**Final Acceptance Punchlist**  
**El Paso County – Department of Public Works - Stormwater Section**

Project Name:	The Gardens at North Carefree
EDARP Filing Number(s):	SF195, CON2012
ESQCP Number:	ESQ1912
Attendees:	DPW SW: Dylan Finley, Mikayla Hartford, Ben Jones DPW Development Services: Brad Walters, Joe Jackman, Spencer Pirzadeh, David Parkerson Developer: Grace Covington
Date of Walk-Thru:	02/01/2024
Walk-Thru Number:	1 <sup>st</sup>

Findings to be addressed prior to scheduling a follow-up walk-thru:

Designer: CD Structure Numbers  
Detailer: MB MB  
Sheet Subset: SHEET 26 OF 34

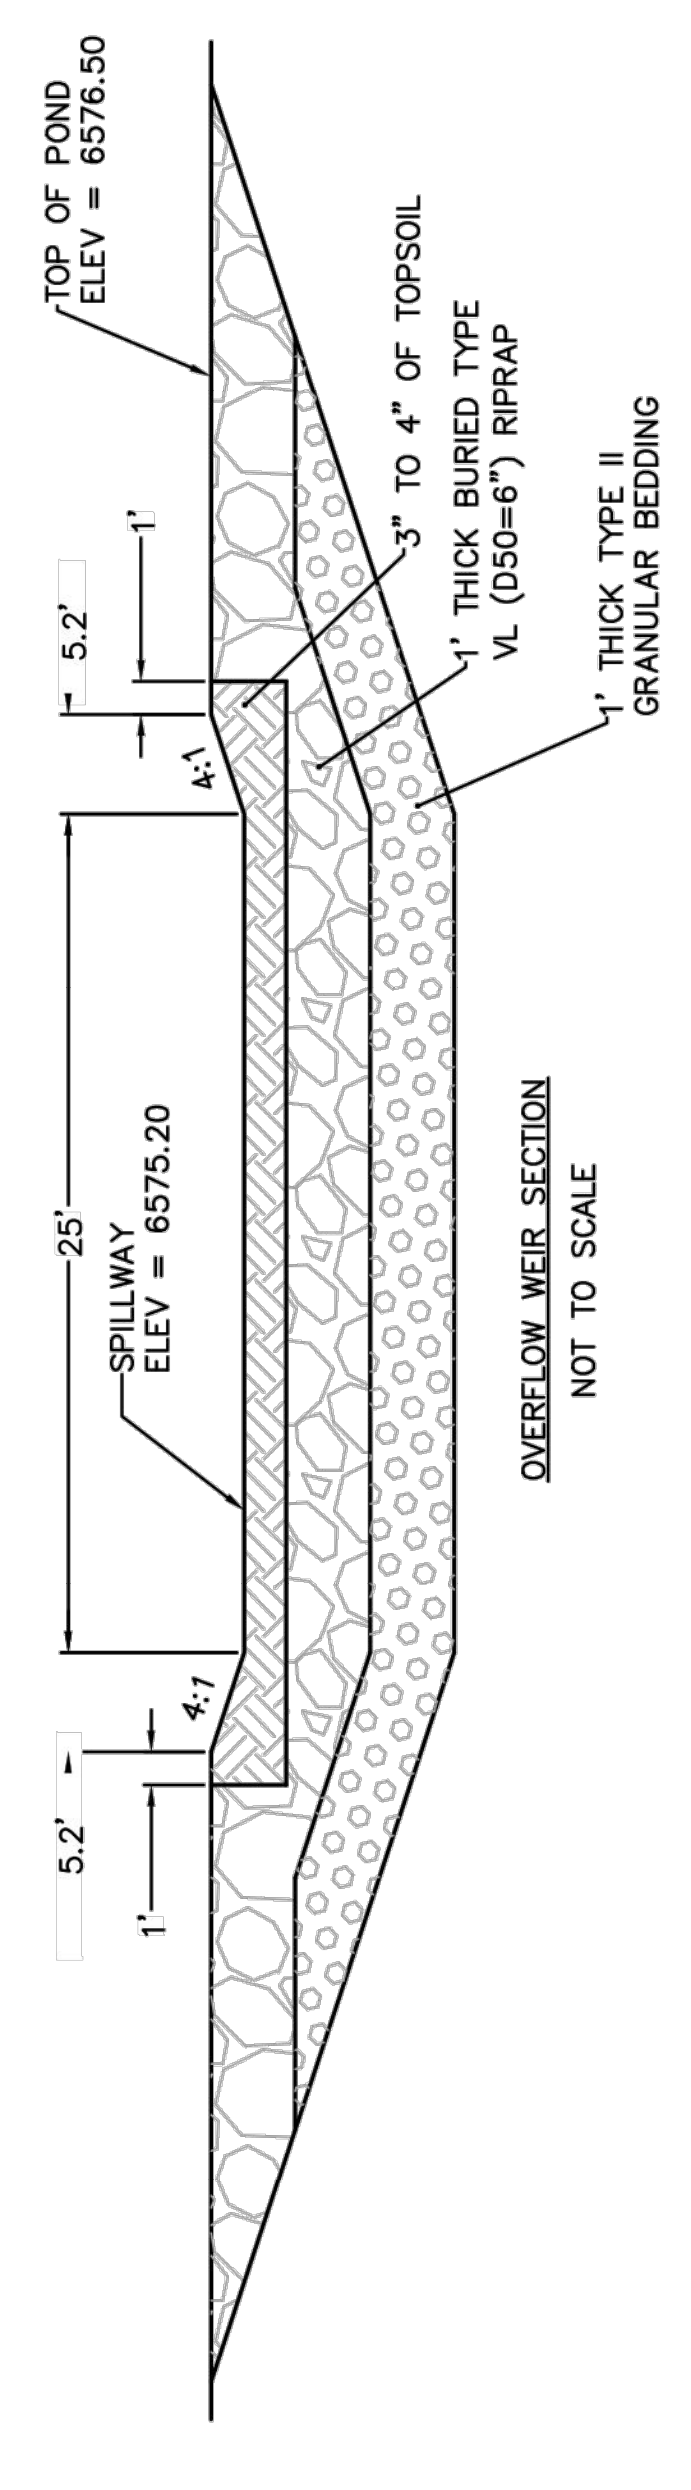
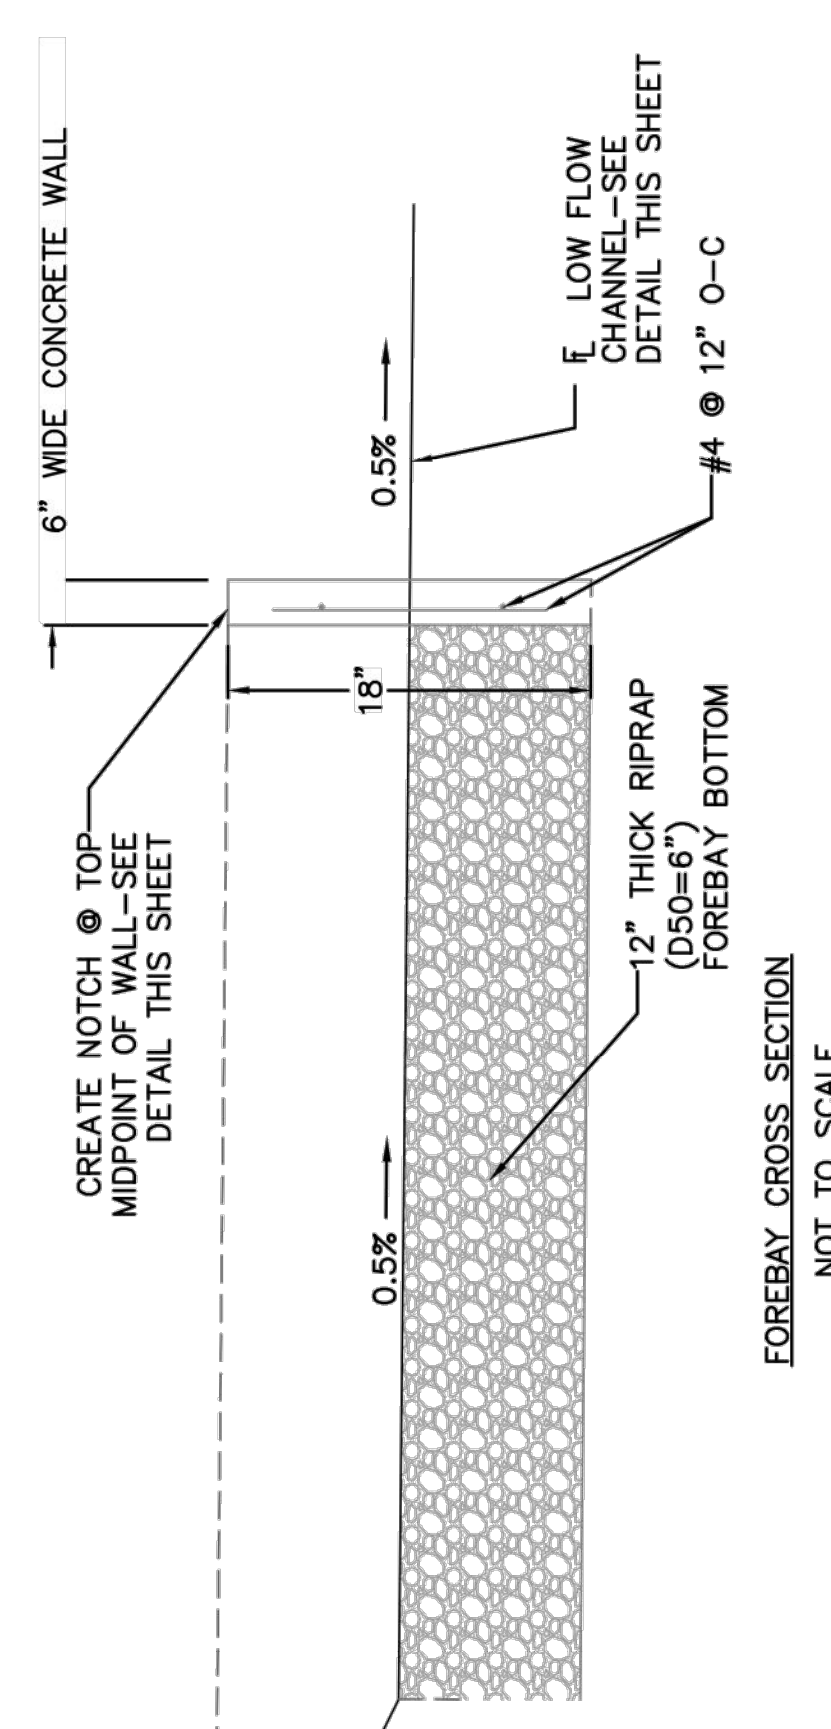
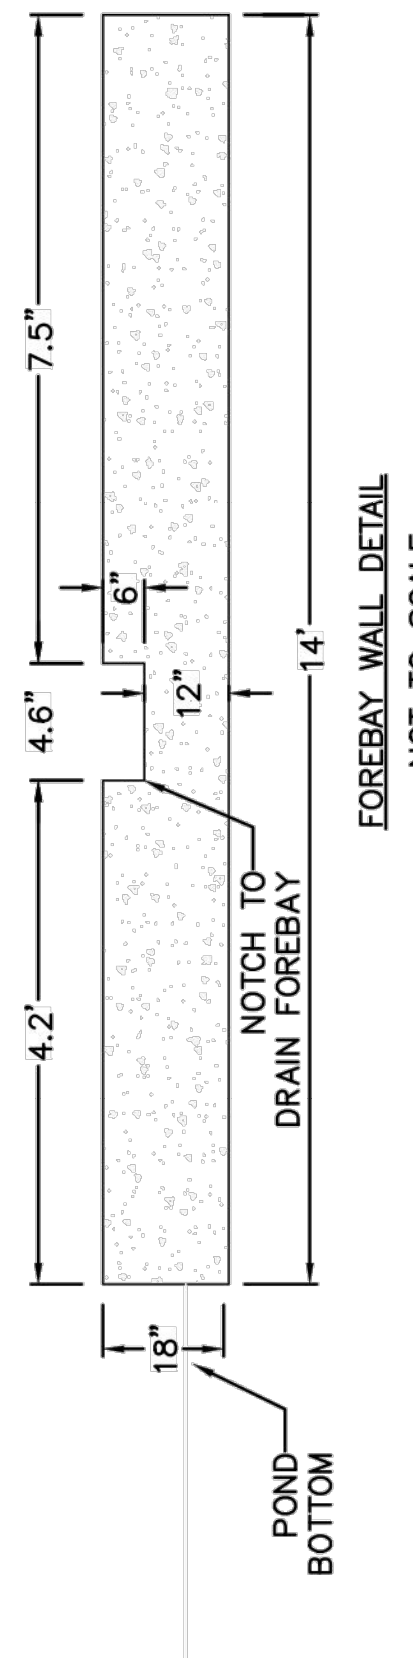
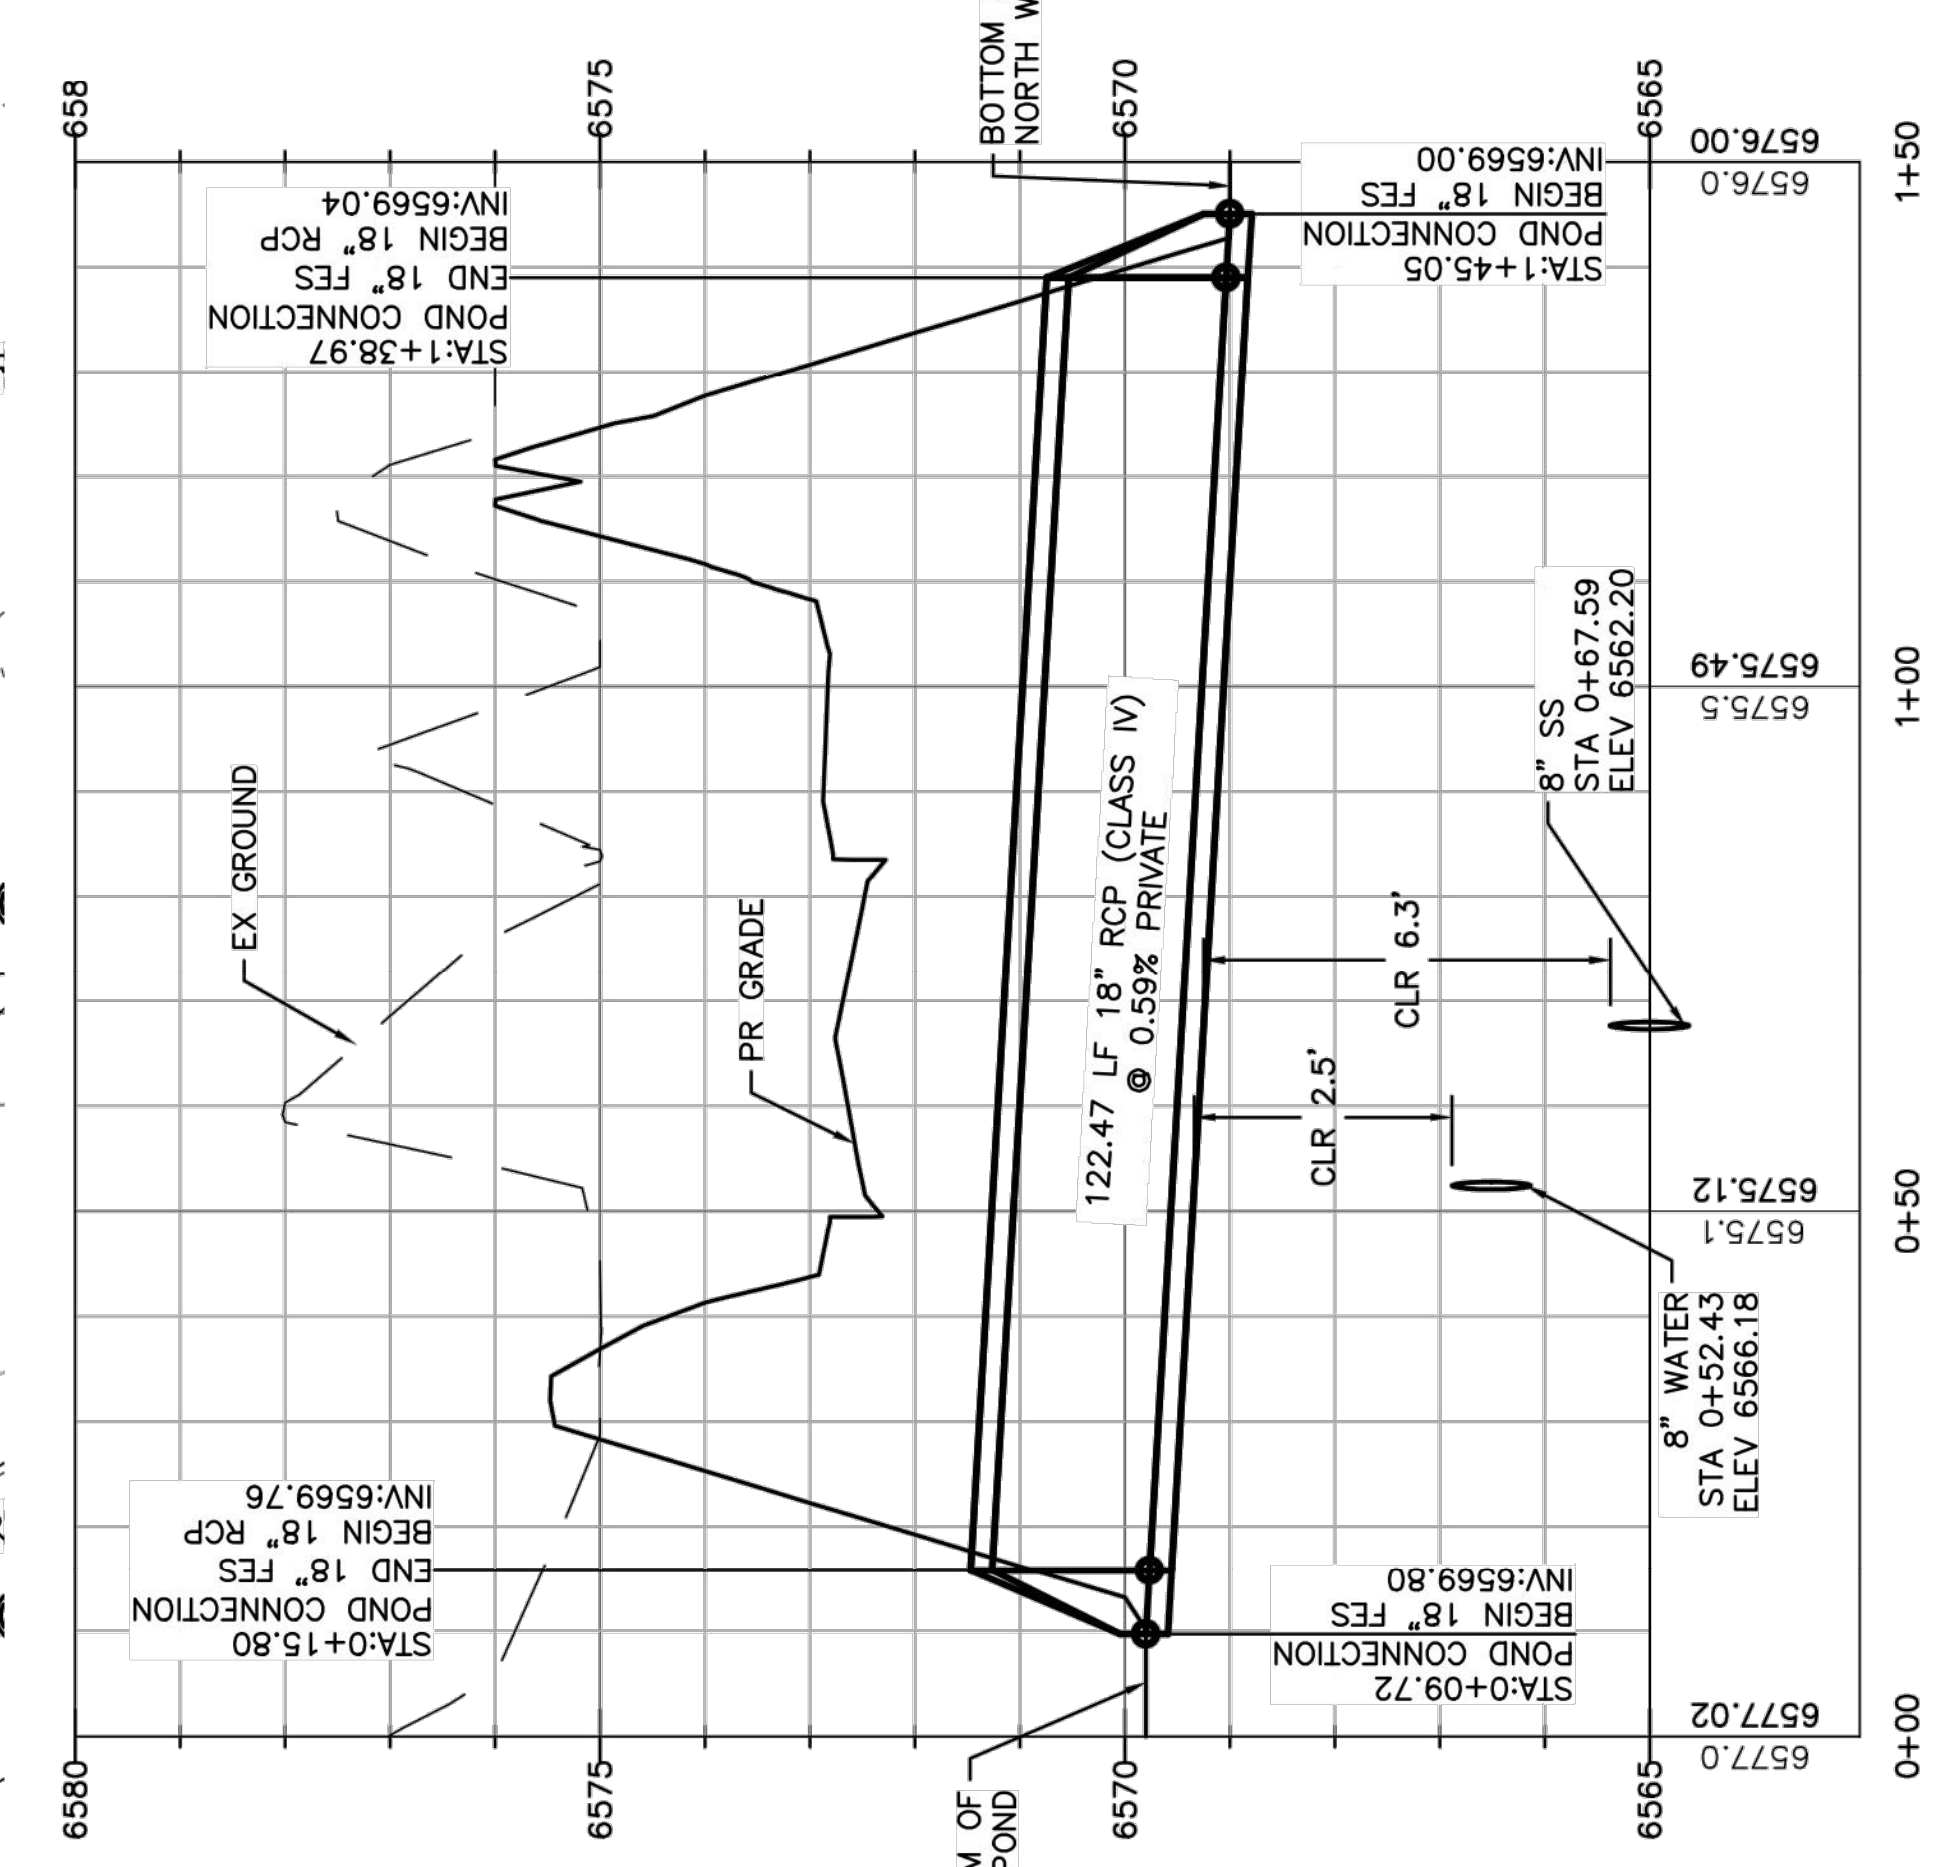
- North embankment requires stabilization.
- **South Pond**
  - Pond forebay not installed per forebay cross section detail. Riprap to be installed per plan with a 6” drop between the top of the forebay curb and the riprap.

- Maintenance road not installed per plan. Re-establish per pond detail, maintenance path to be 12-foot wide and extending to the pond bottom.
  - Reshape the emergency spillway (called overflow weir in plans) so that it is the lowest point along the pond embankments. Properly restabilize.

Photo 8: South pond maintenance road not installed per spec. ( 8' wide with 2" rock and extends to forebay)

Photo 9: South pond forebay not installed per spec. (Page 25 Forebay cross section)

Photo 11: Reshape the overflow weir so that it is the lowest point along the pond embankments
